**From:** [Charles Judson](#)  
**To:** [A47 Blofield to North Burlingham](#)  
**Subject:** A47 Blofield - North Burlingham - Hearing Action Points  
**Date:** 06 September 2021 13:18:09  
**Attachments:** [Acle Neighbourhood Plan extract - policy 5.pdf](#)

Please accept the following responses on behalf of Broadland District Council to the Hearing Action Points:

Issue Specific Hearing 1 – Draft Development Consent Order (dDCO) - Tuesday 17 August 2021

SUITABLE FOR INFORMATION

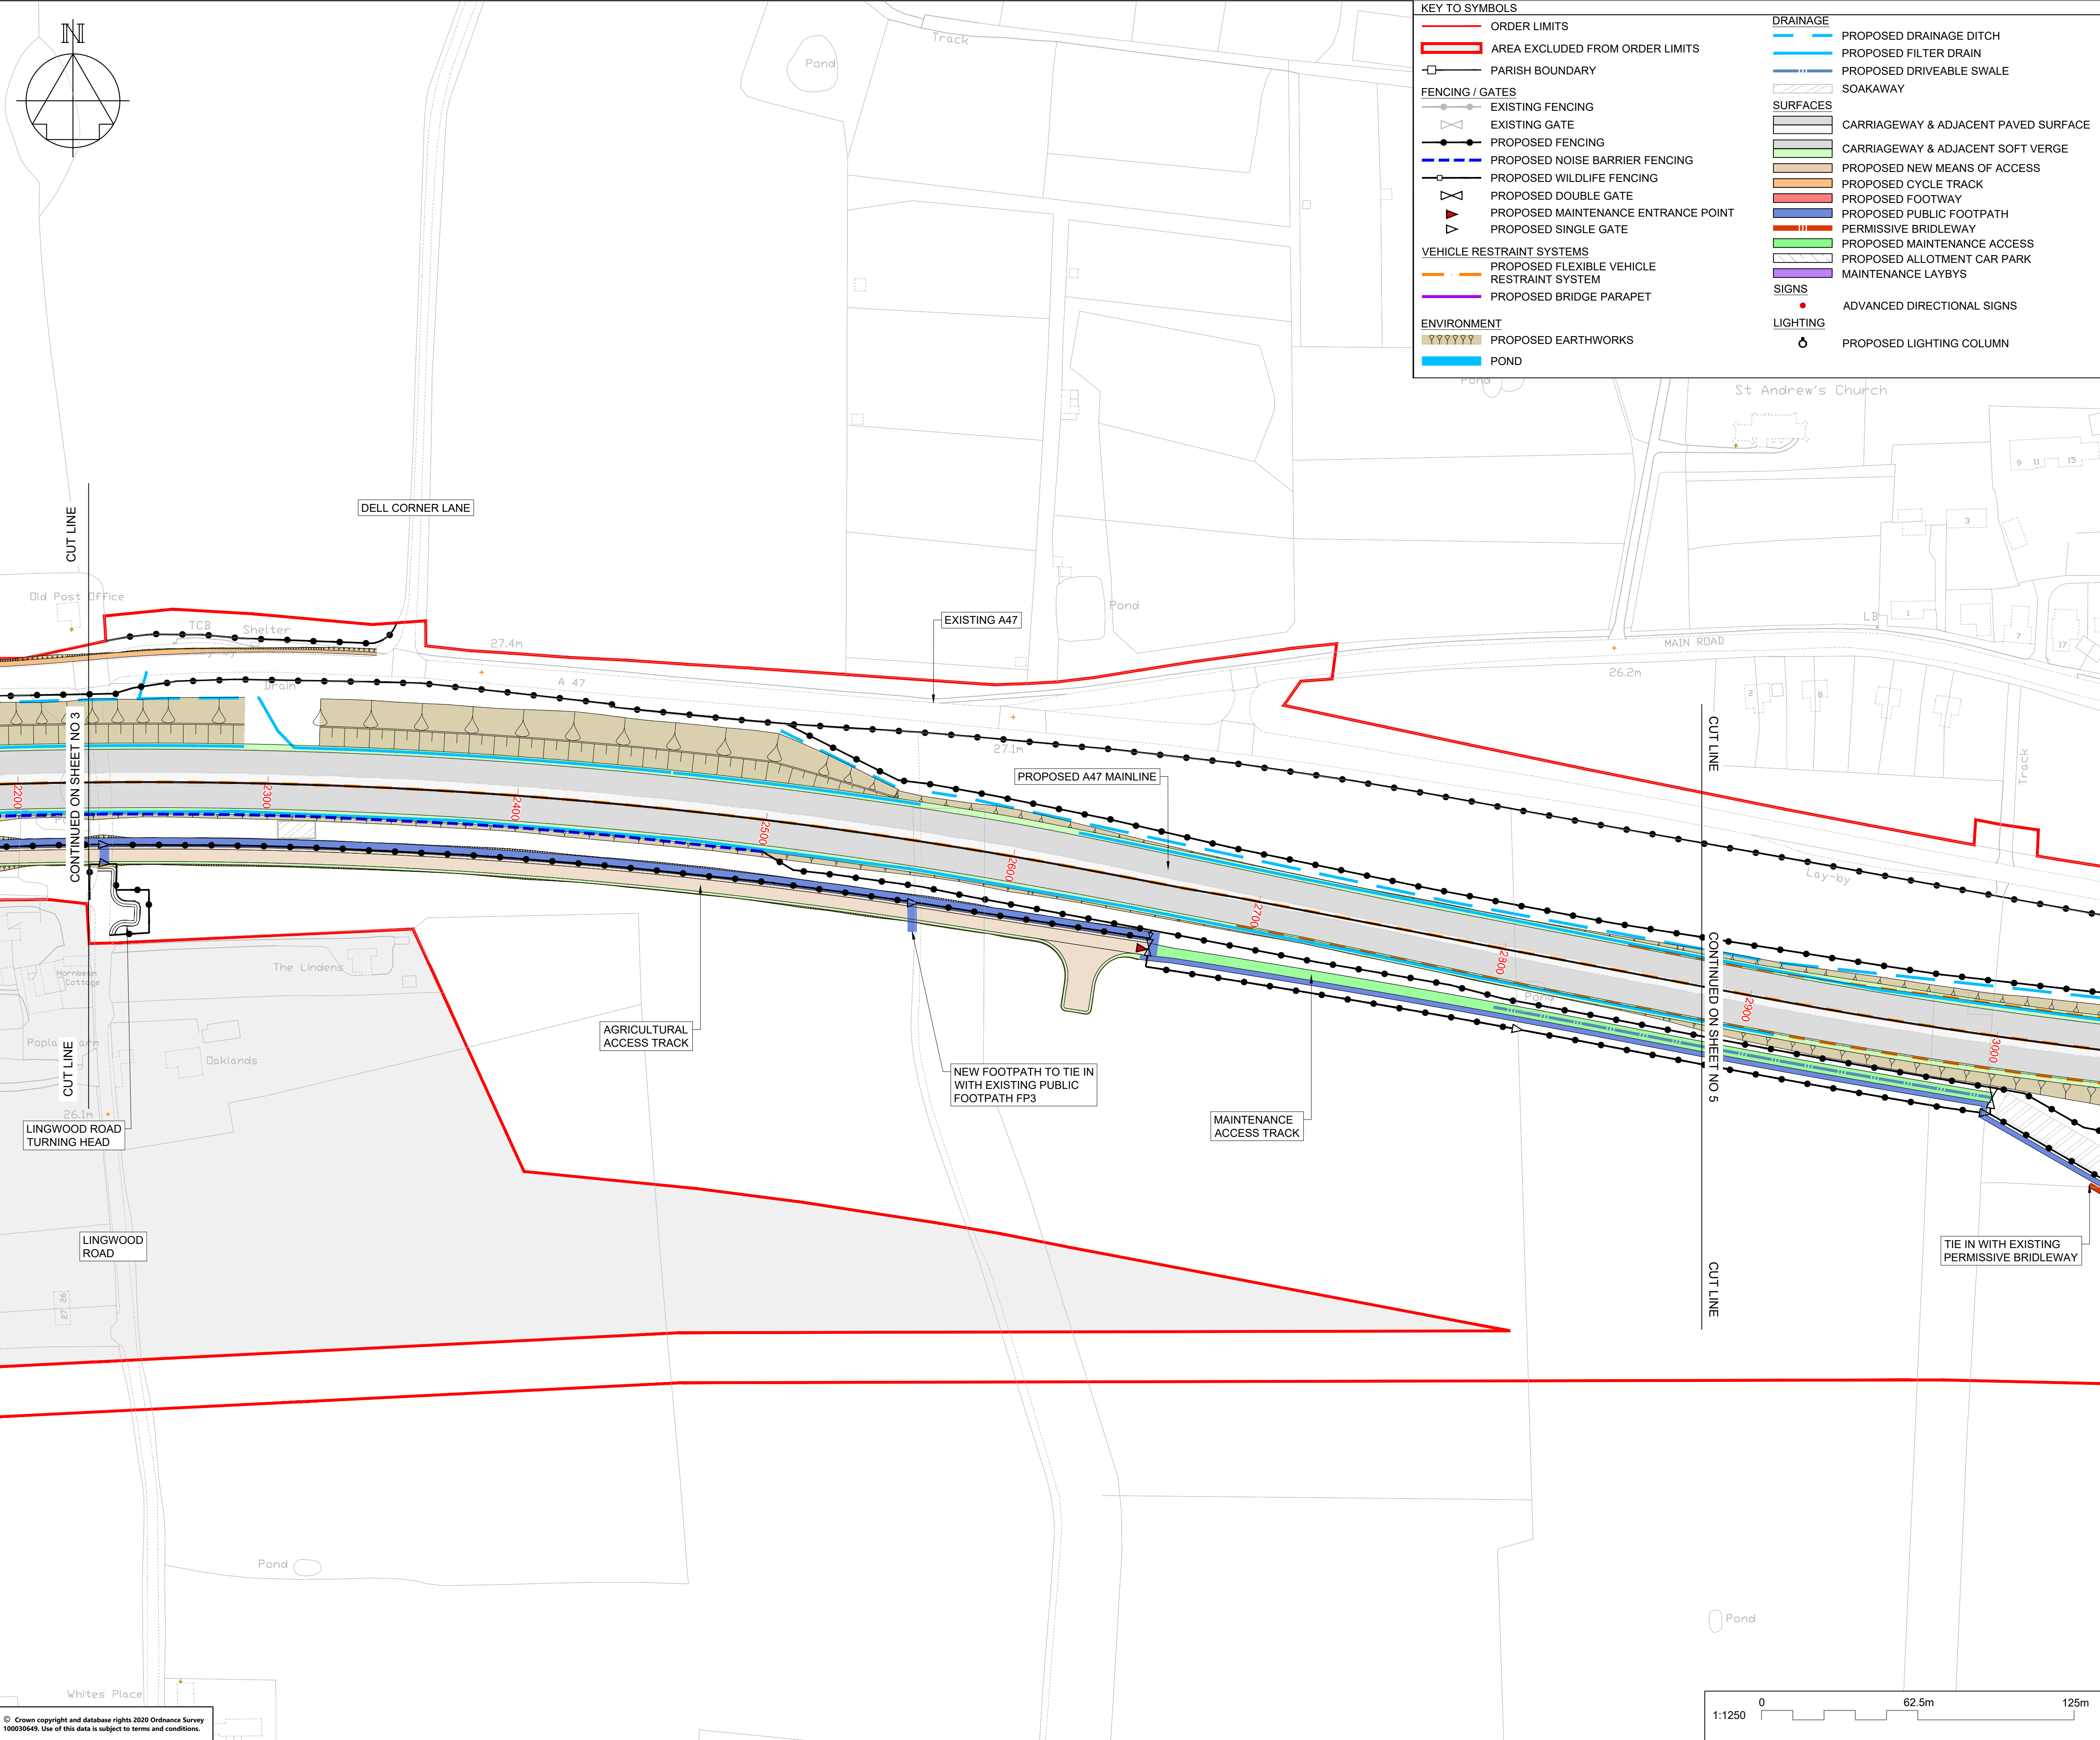
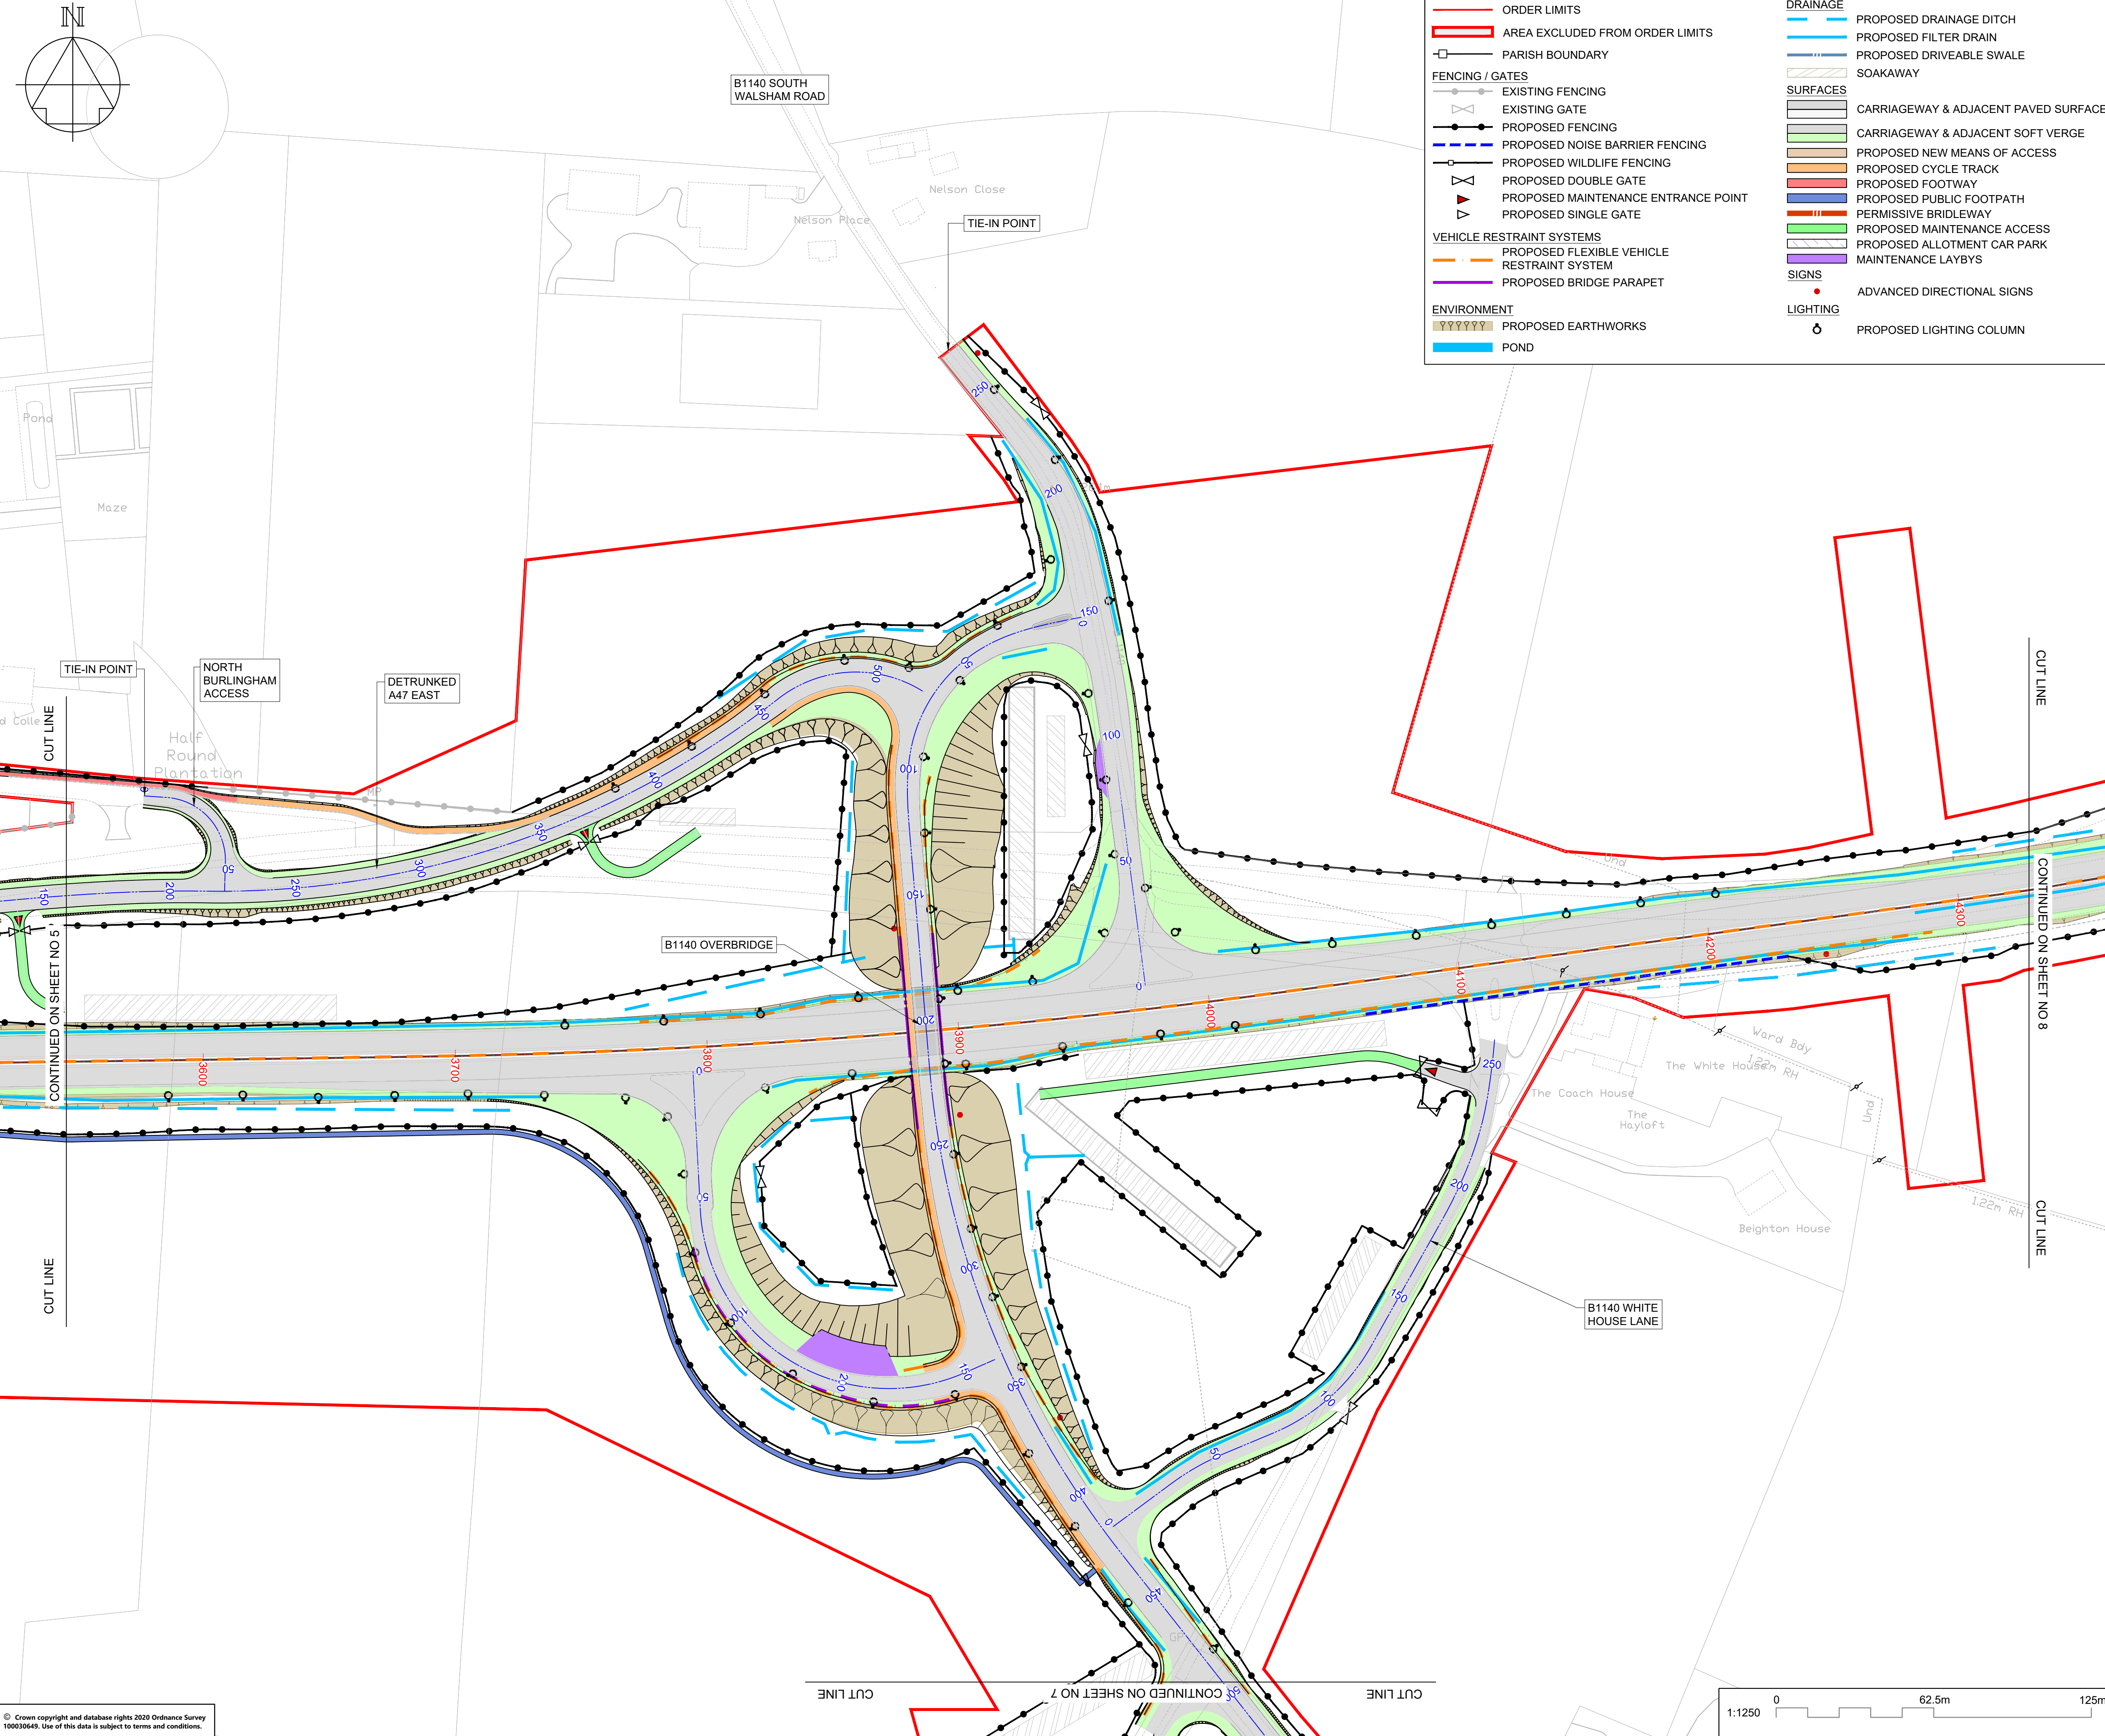
Item 11 – Broadland District Council considers that the general arrangement plans, which do not include details of elevations/sections/design/materials of the structures, would be insufficient for the purposes of R3.
